From: Laura Gibbons [REDACTED]
Sent: 04 May 2021 15:28
To: Anita Gardner <Anita.Gardner@arun.gov.uk>
Cc: Planning.Responses <Planning.Responses@arun.gov.uk>
Subject: Re: FW: FW: Planning Consultation on: CM/11/21/DOC

Application No: CM/11/21/DOC

Site Address: Scyld Horsemere Green Lane Climping BN17 5QZ

Description of Works: Approval of details reserved by condition imposed under CM/21/19/PL relating to conditions 11-surface water drainage scheme, 12-discharge of flows to water courses or for the culverting, diversion, infilling or obstruction of any water course on or adjacent to site & 13-maintenance and management of surface water drainage system.

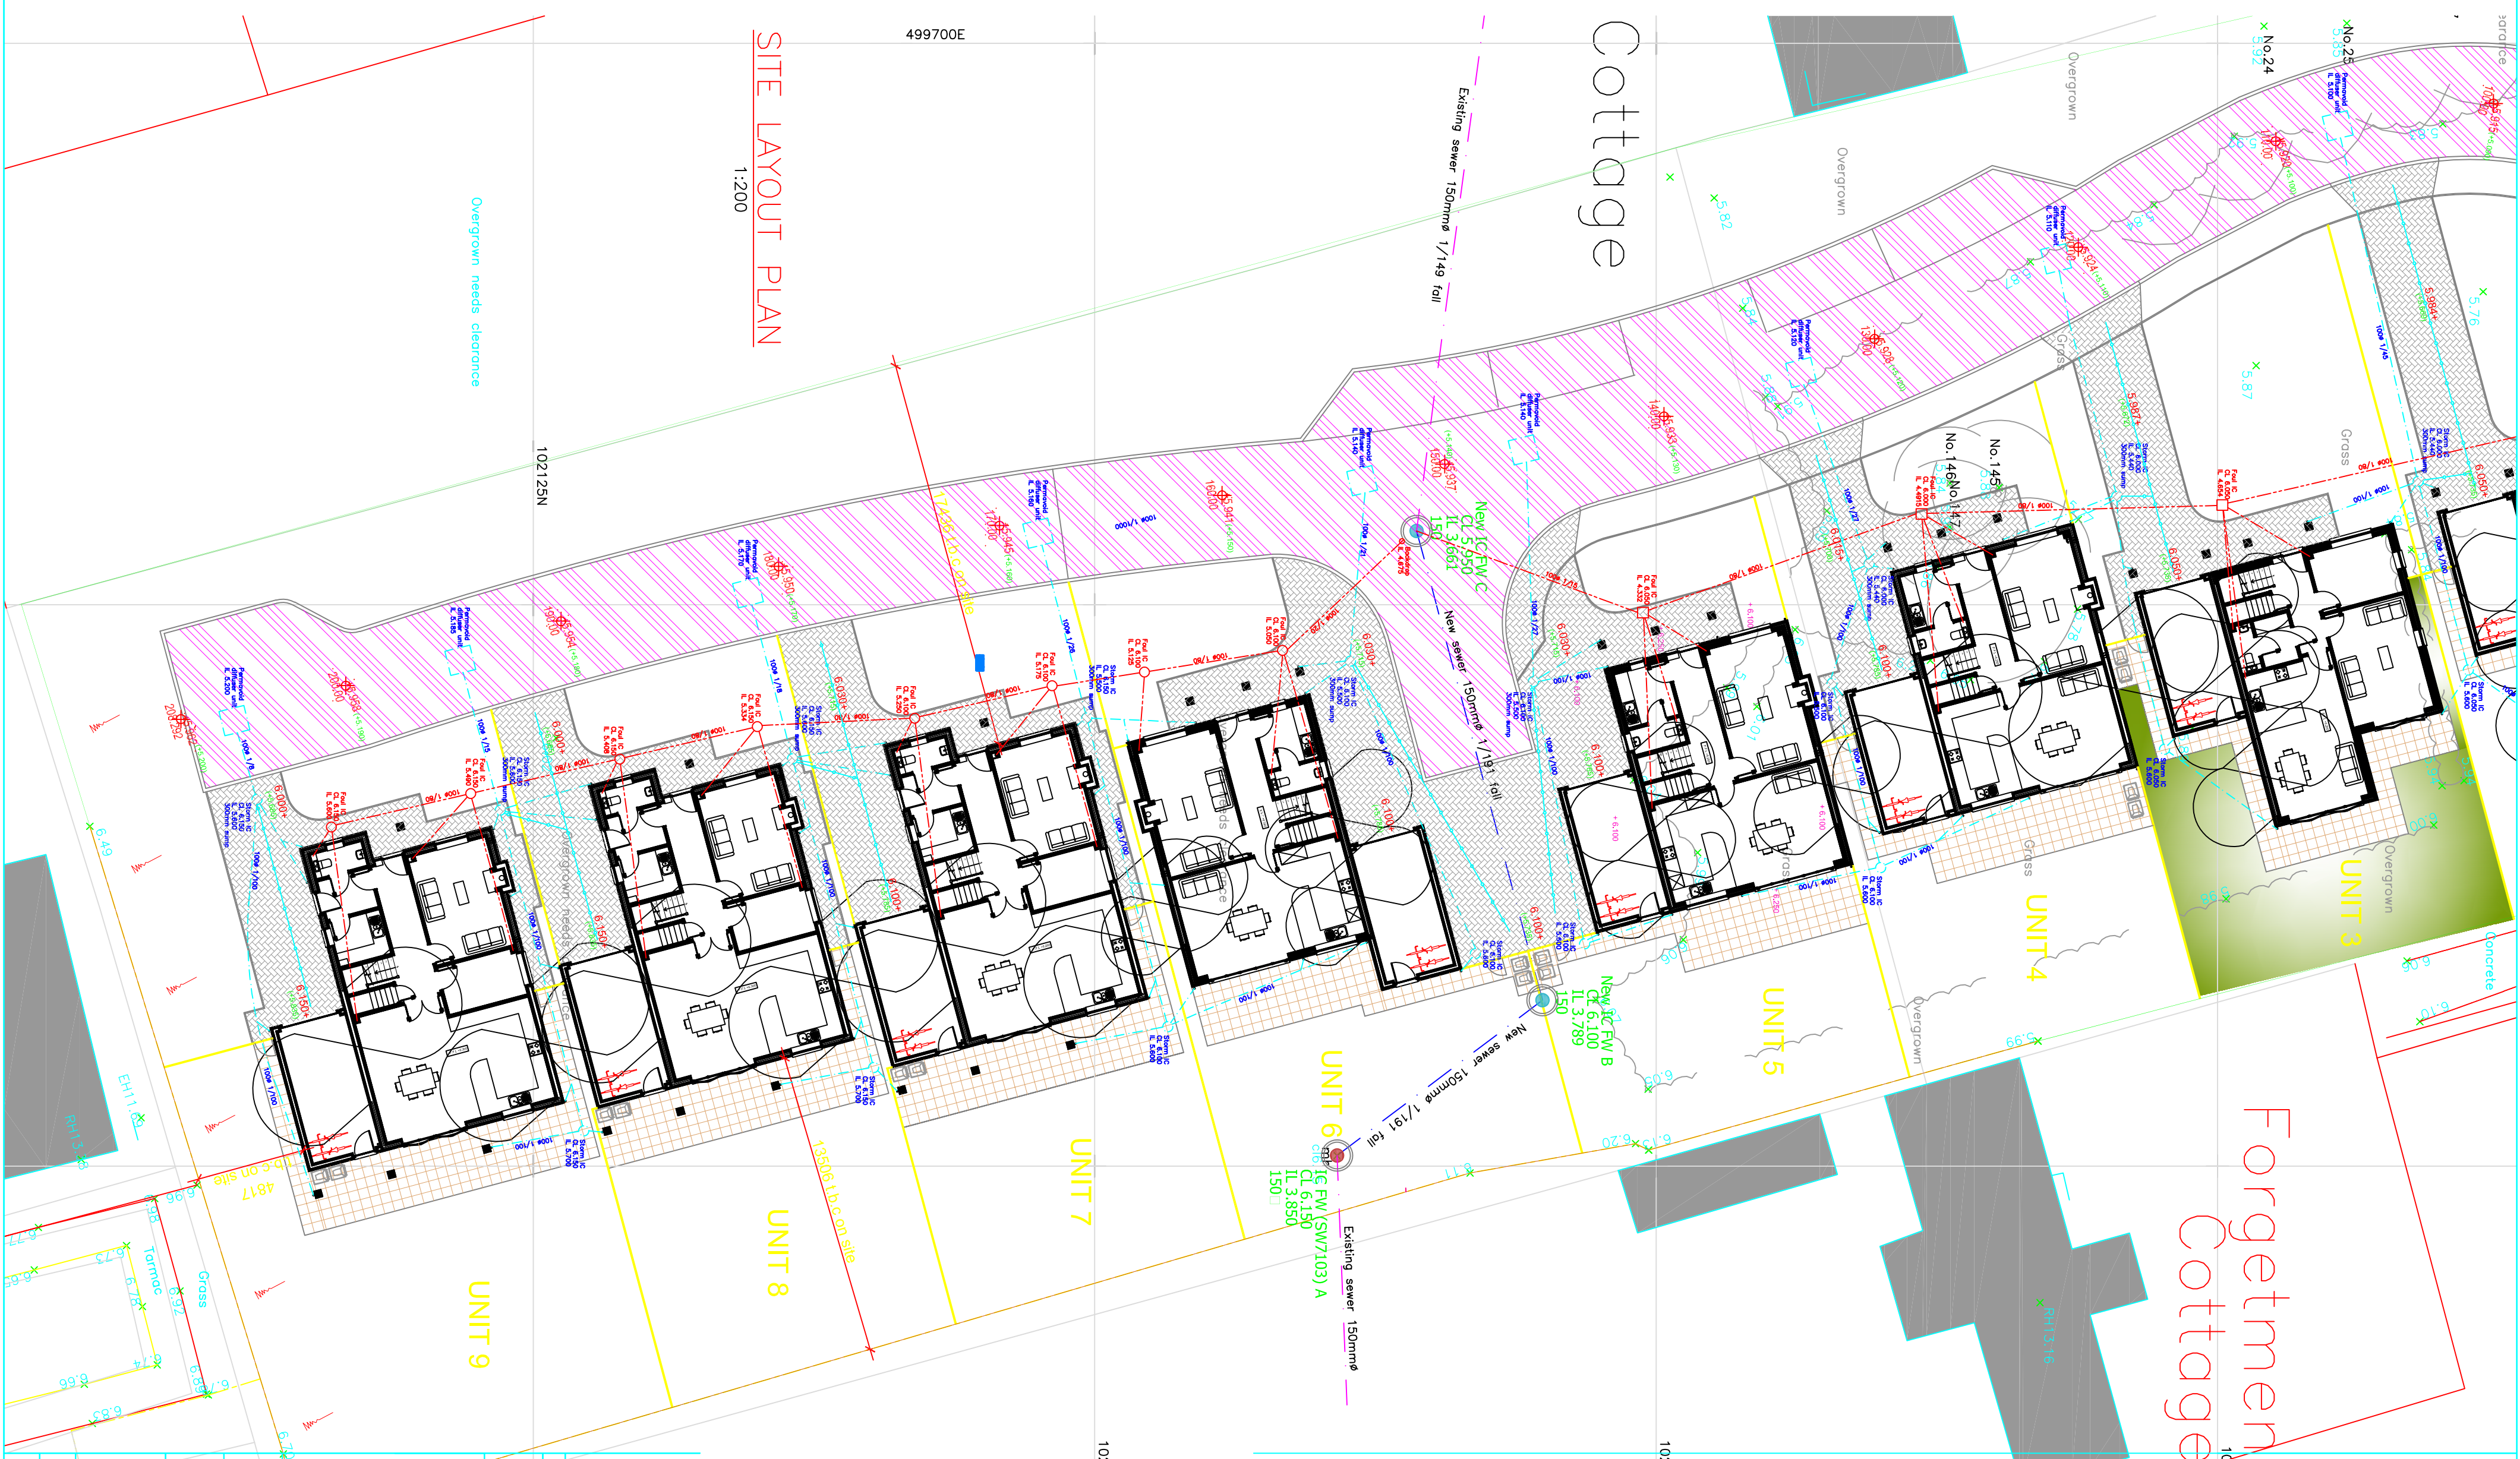
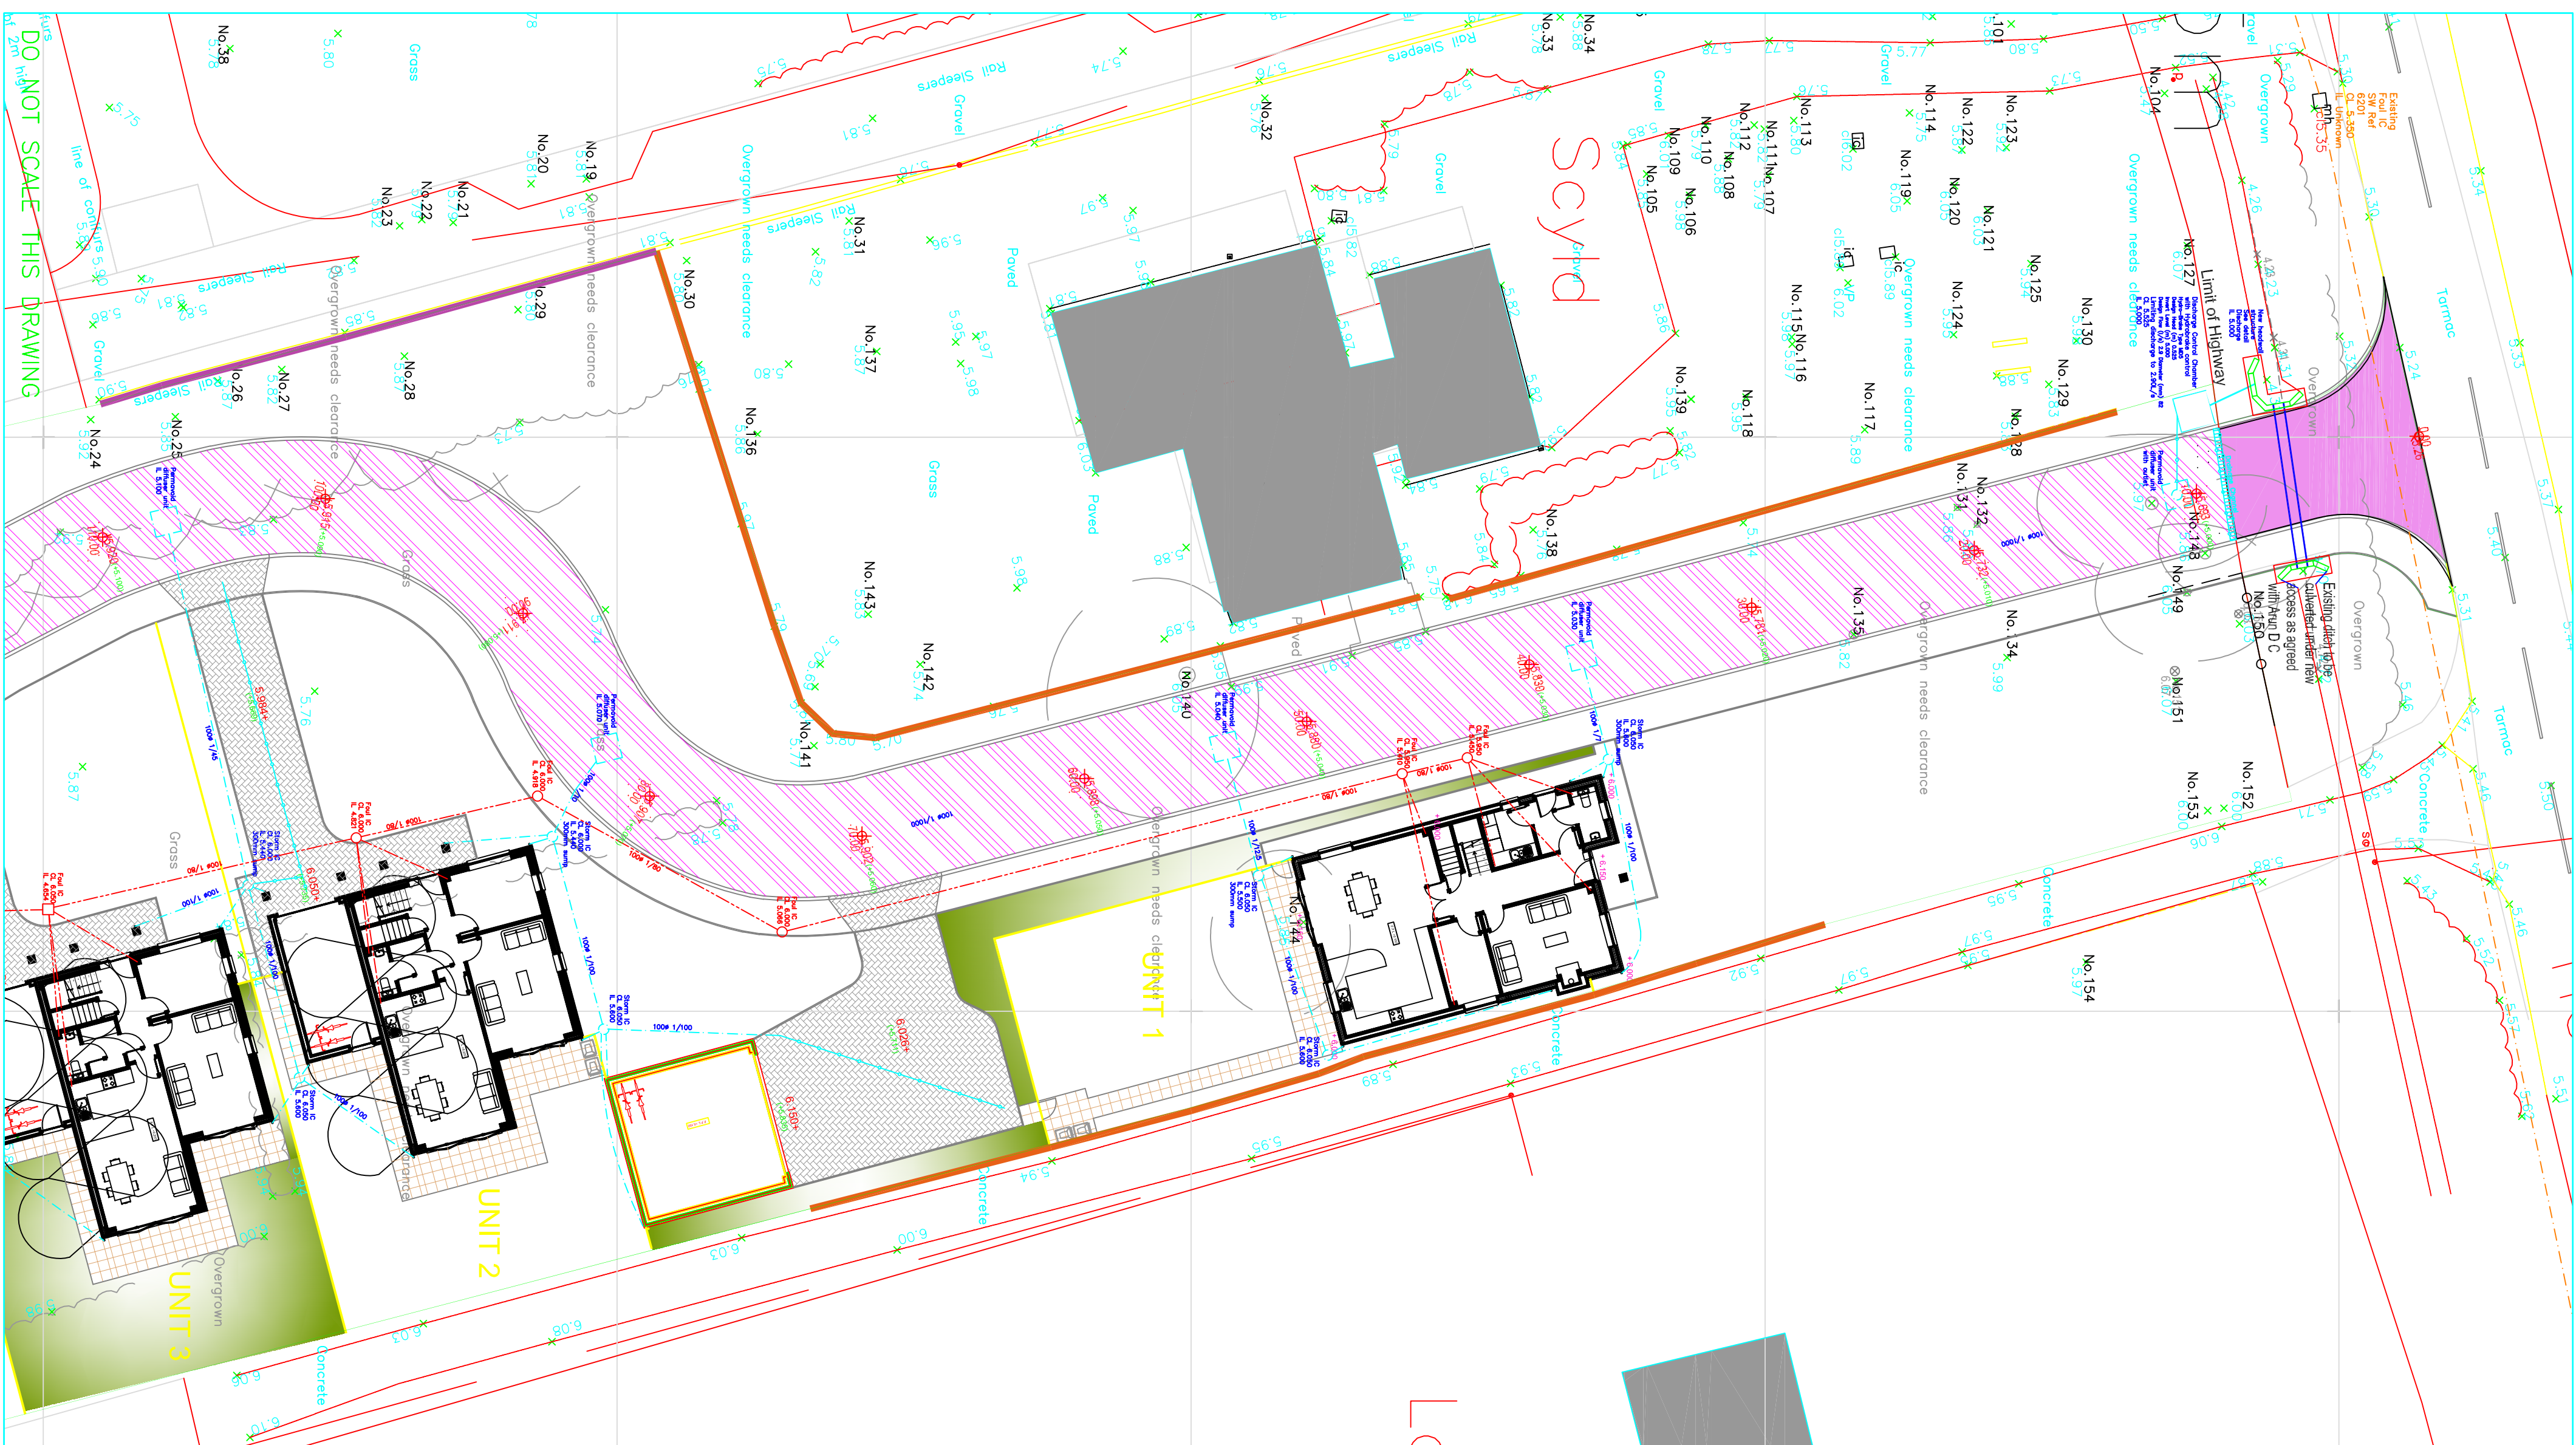
4. Please detail finish and formation levels of permeable paving on plan. These are shown in the detailed sections but have also been added to the plan. *Please detail on driveways.*

6. Please detail all pipe diameters and falls on plan. Plan updated. *Please detail pipes in permeable paving driveways.*
1. No connections are shown to/ from the permeable car park areas. We have now shown a connection into the storm drainage system.

4. Please detail finish and formation levels of permeable paving on plan. These are shown in the detailed sections but have also been added to the plan. *Please detail on driveways. Levels and subbase base levels are given at the top of driveways, I have added extra levels at mid way down the driveways.*

6. Please detail all pipe diameters and falls on plan. *Plan updated. Please detail pipes in permeable paving driveways. Shown on details within details 1 of 2*
